Re: Response to Review Comments
Monument Ridge East
Monument Hill Road and Palmer Divide Road
El Paso, Colorado
Entech Job No. 230248

ENTECH ENGINEERING, INC. RESPONSES

EP-24-0077 Monument Ridge East
N½ Section 2, T11S, R67W, 6th Meridian
39.1284, -104.8624
File Number: SP241
Preliminary plan to create 342 residential lots on 63 acres.

# MONUMENT RIDGE EAST

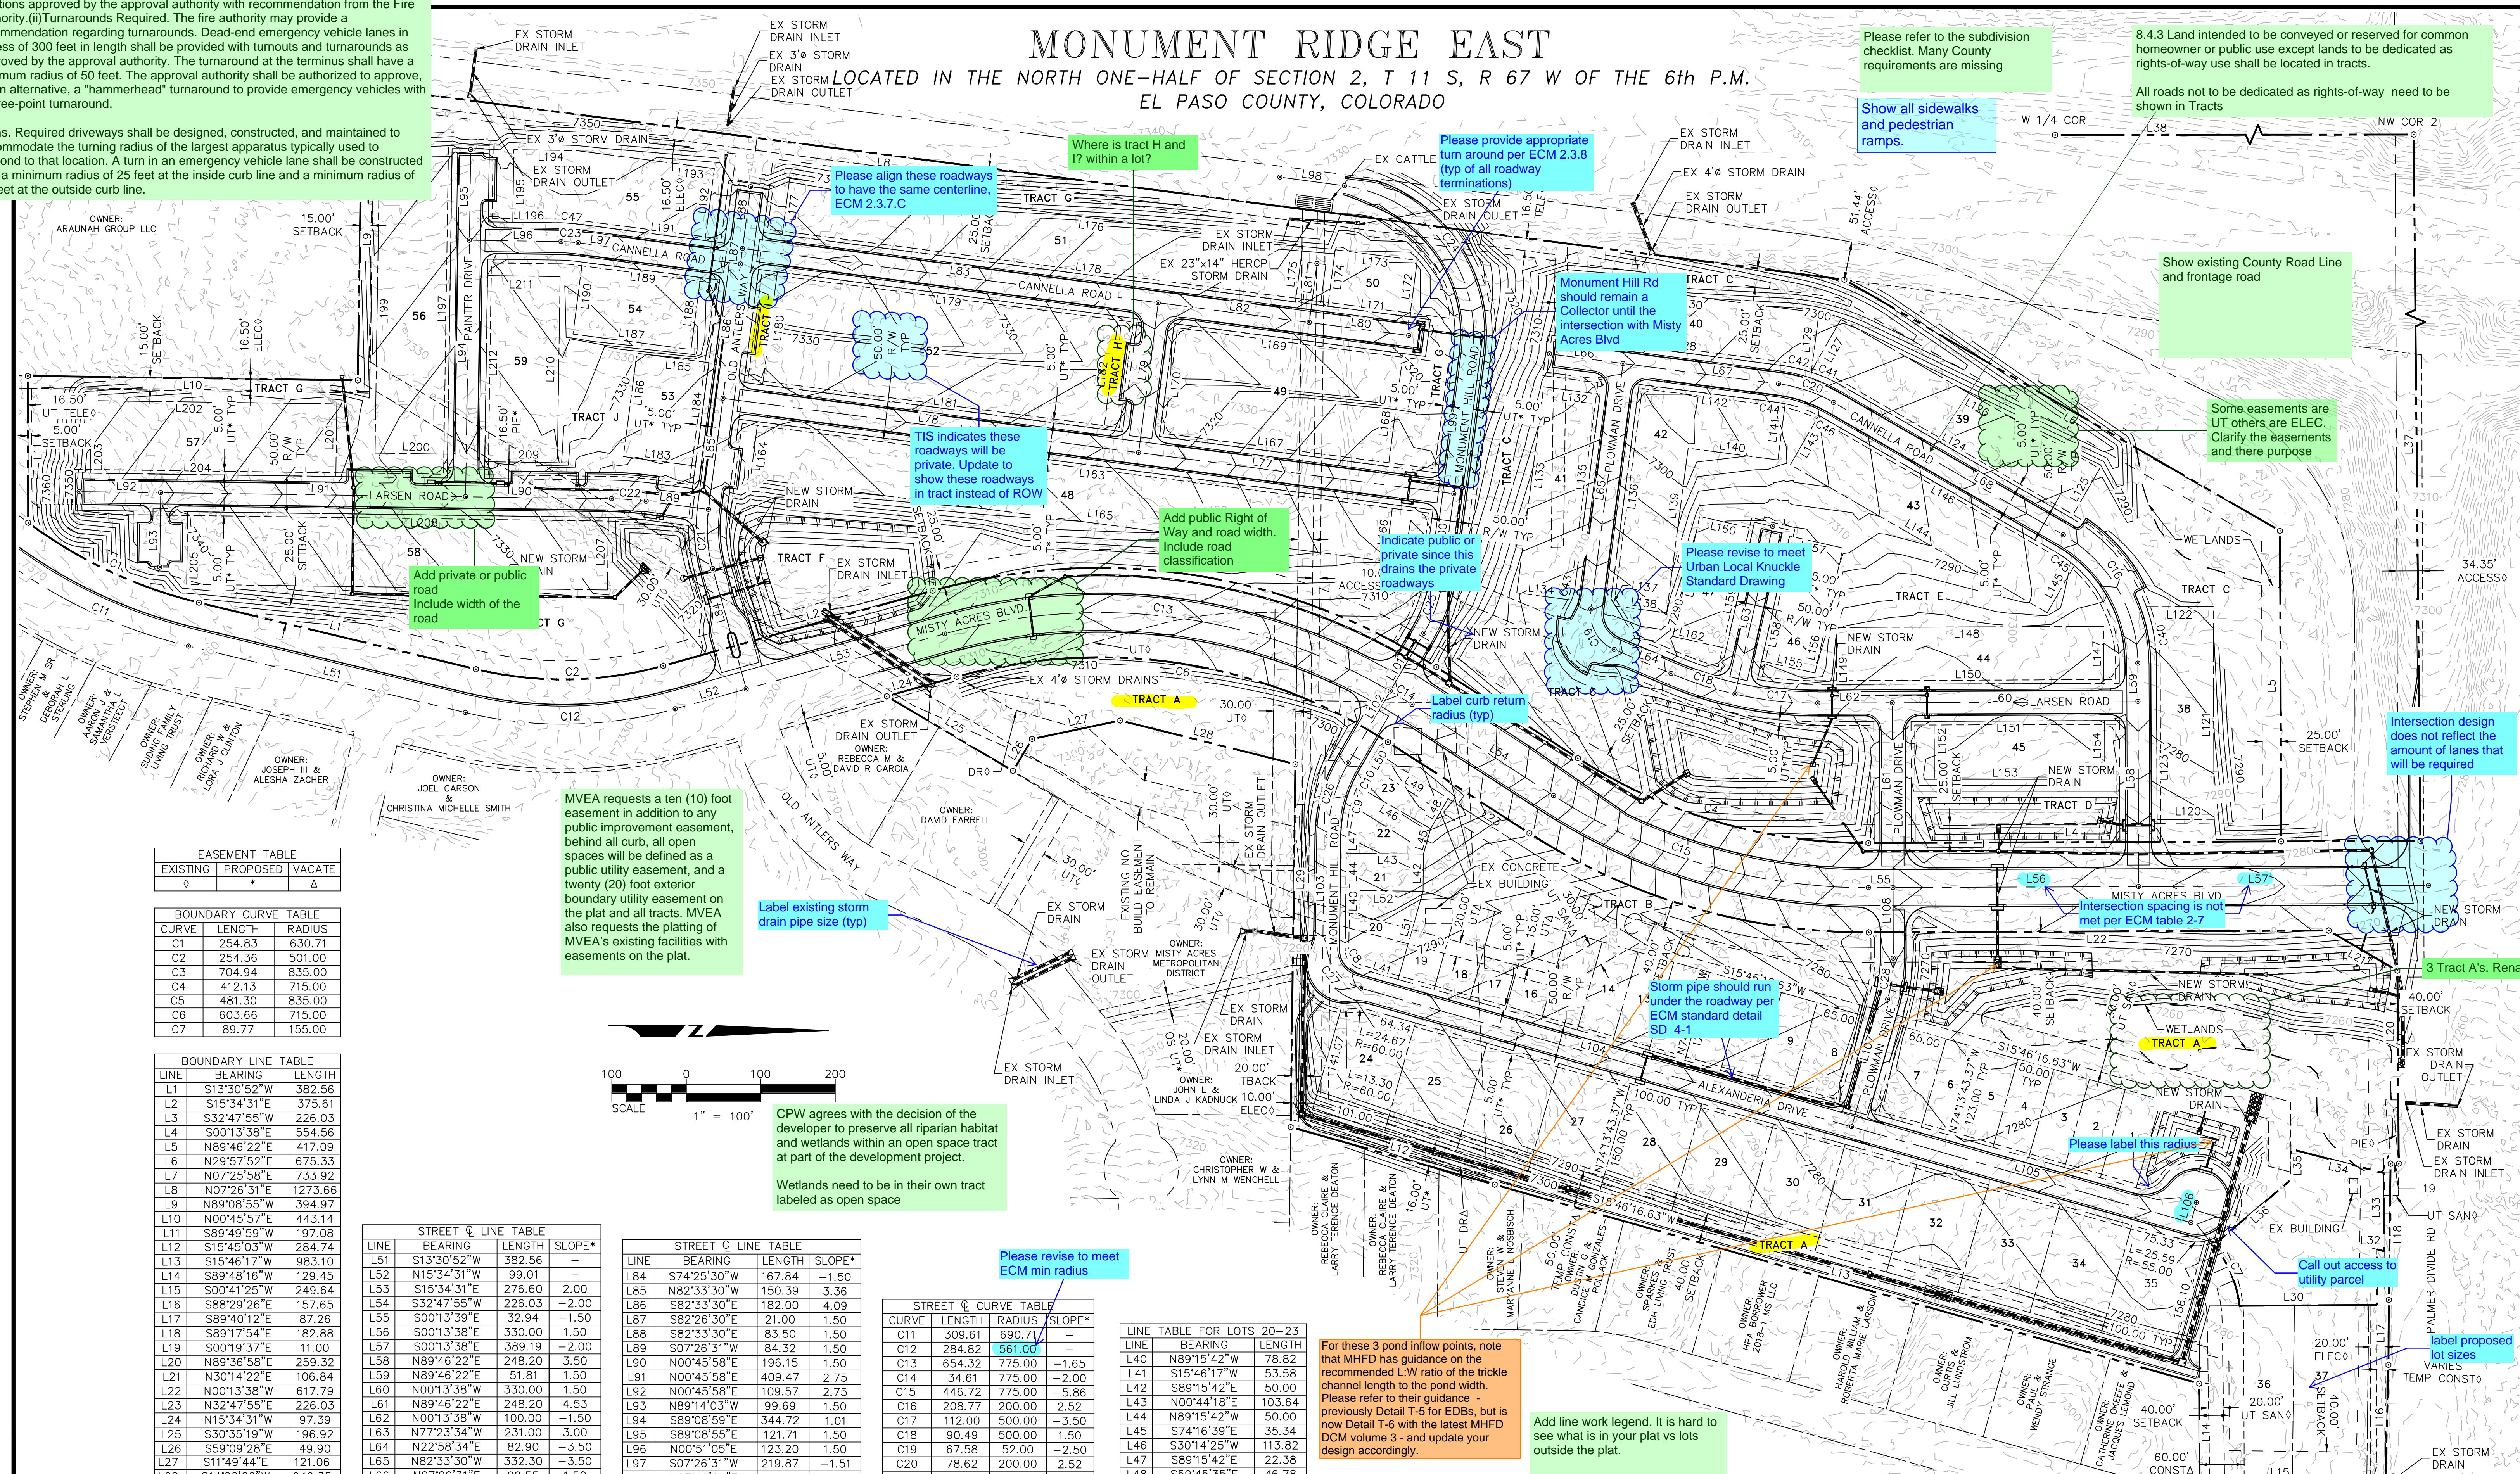
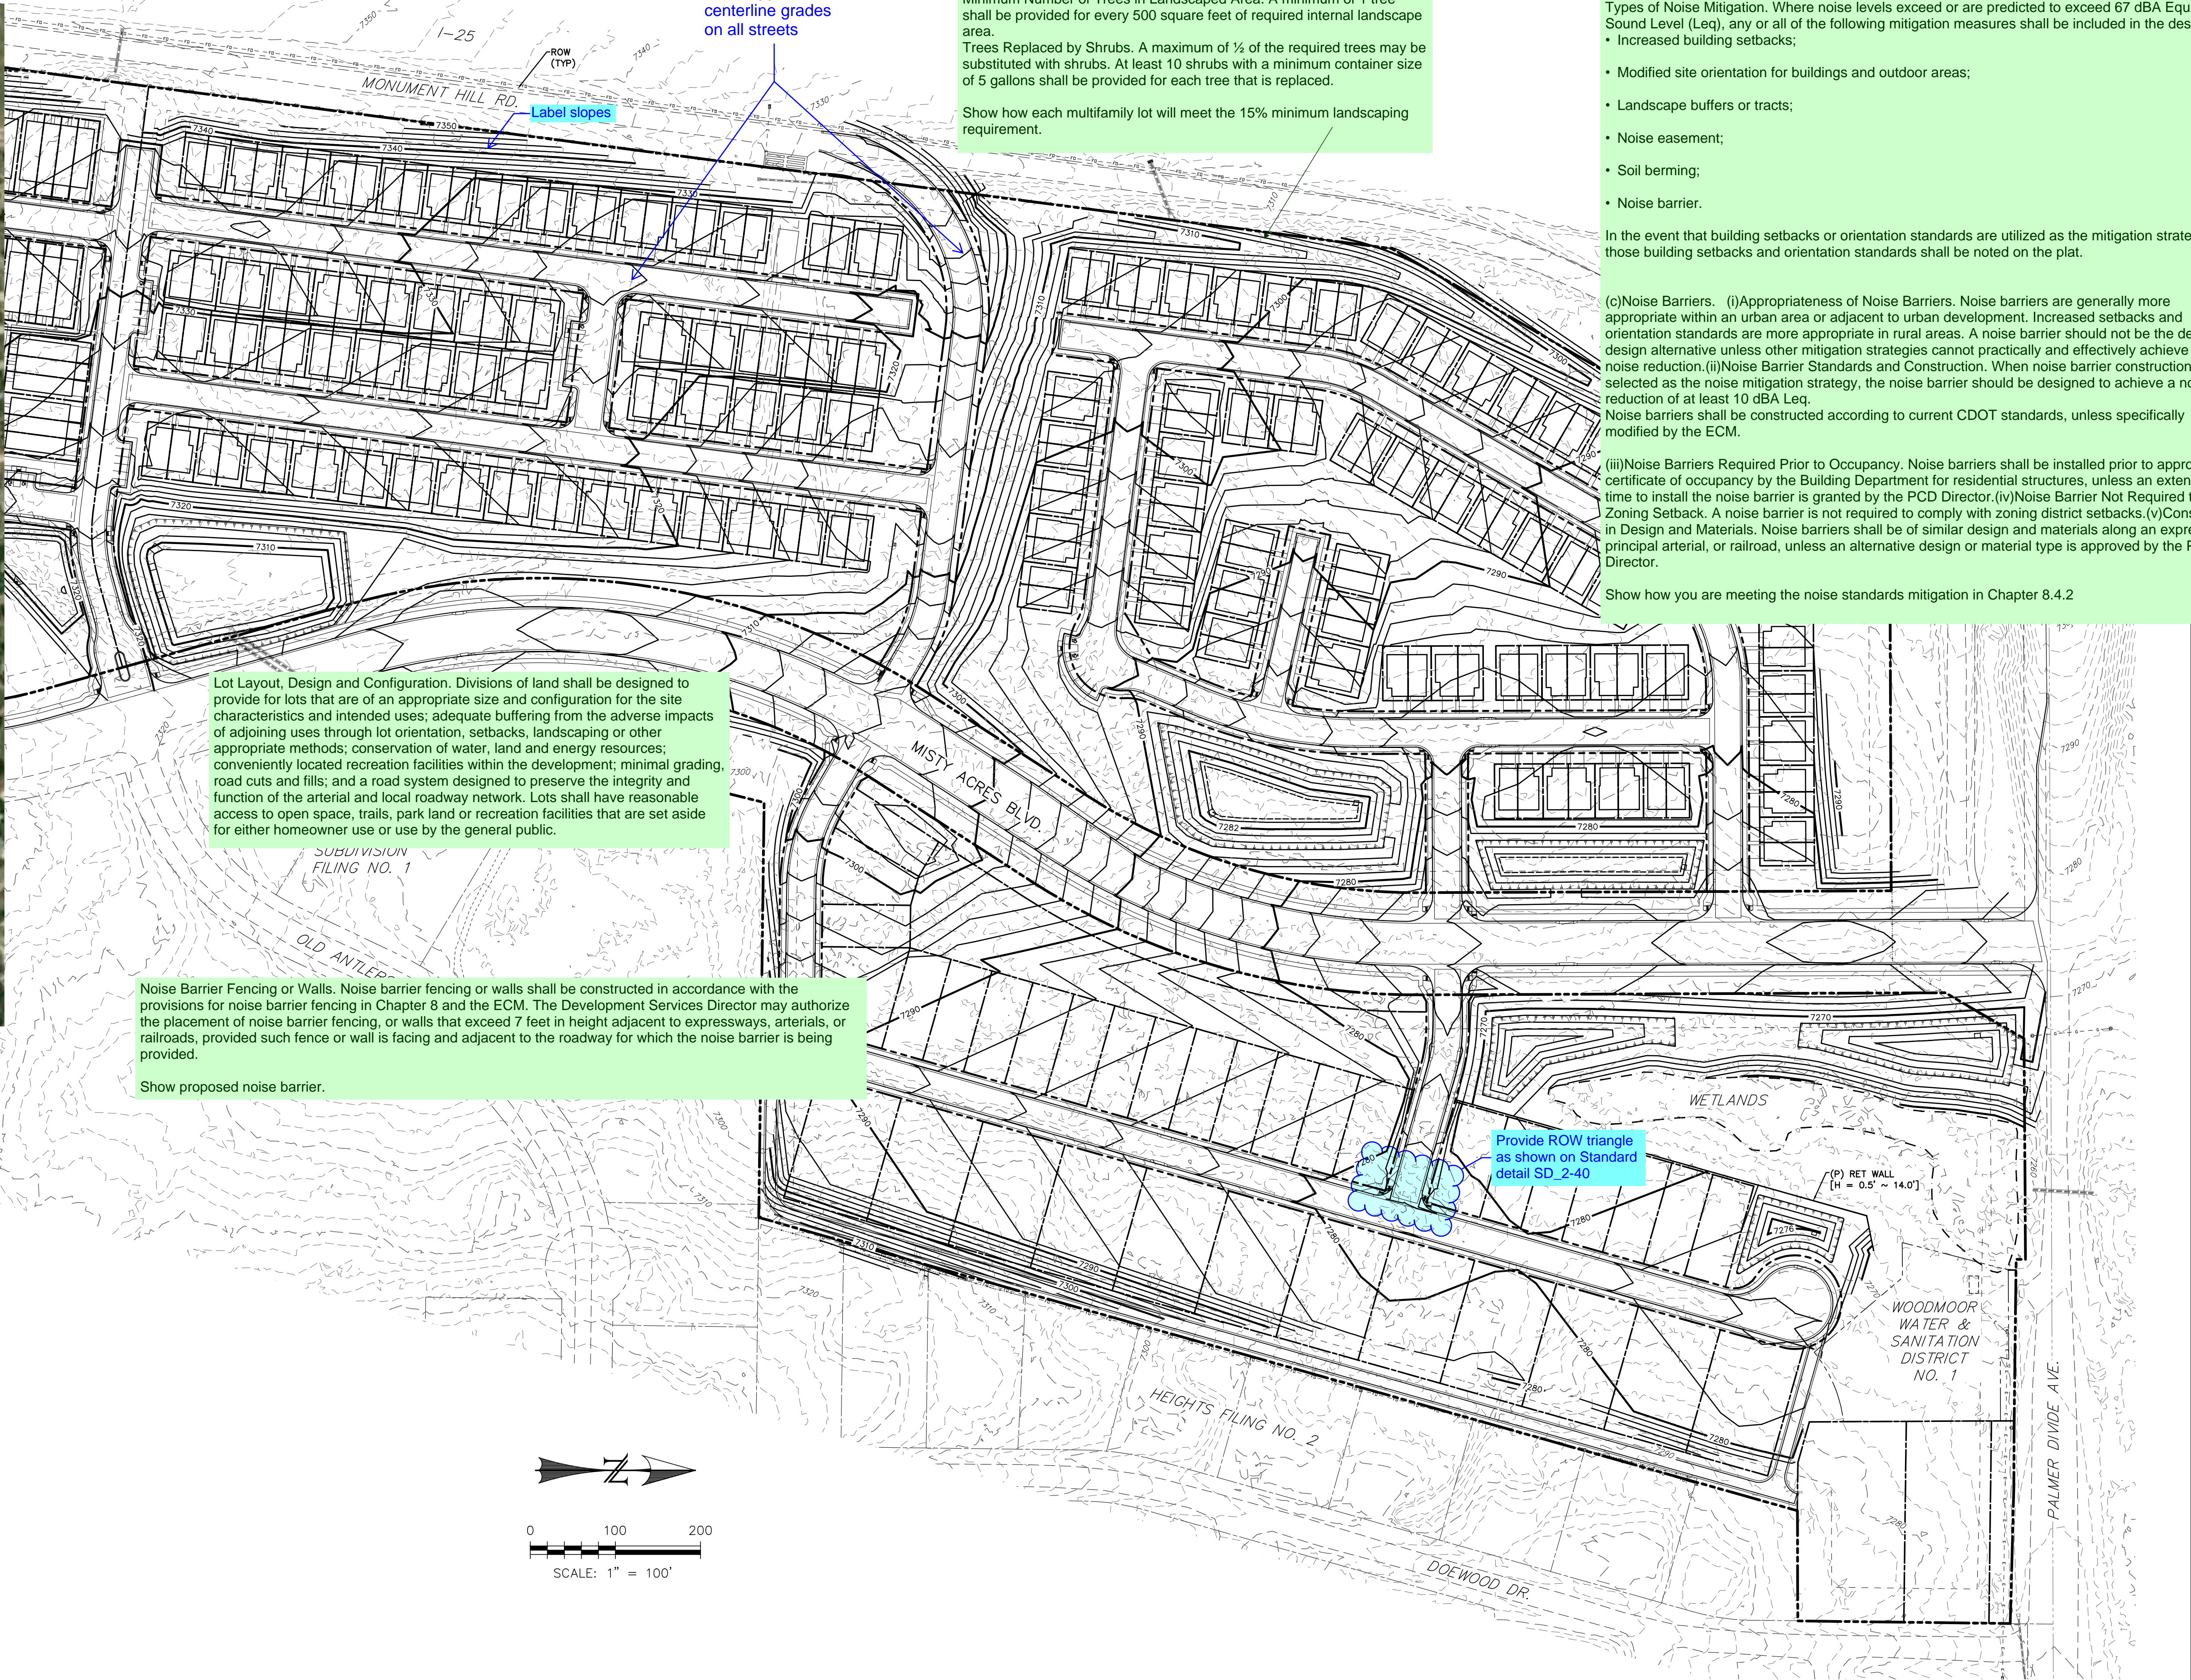
4. A geologic hazard note is not included in the preliminary plan drawings. CGS recommends updating Figure 7 of Entech’s report and adding a note to the preliminary plan/plat listing the geologic hazards and constraints, along with mitigation measures.

Entech Response to Comment 4: Figure 7 has been updated, and a geologic hazard note provided for the preliminary plan/plat.
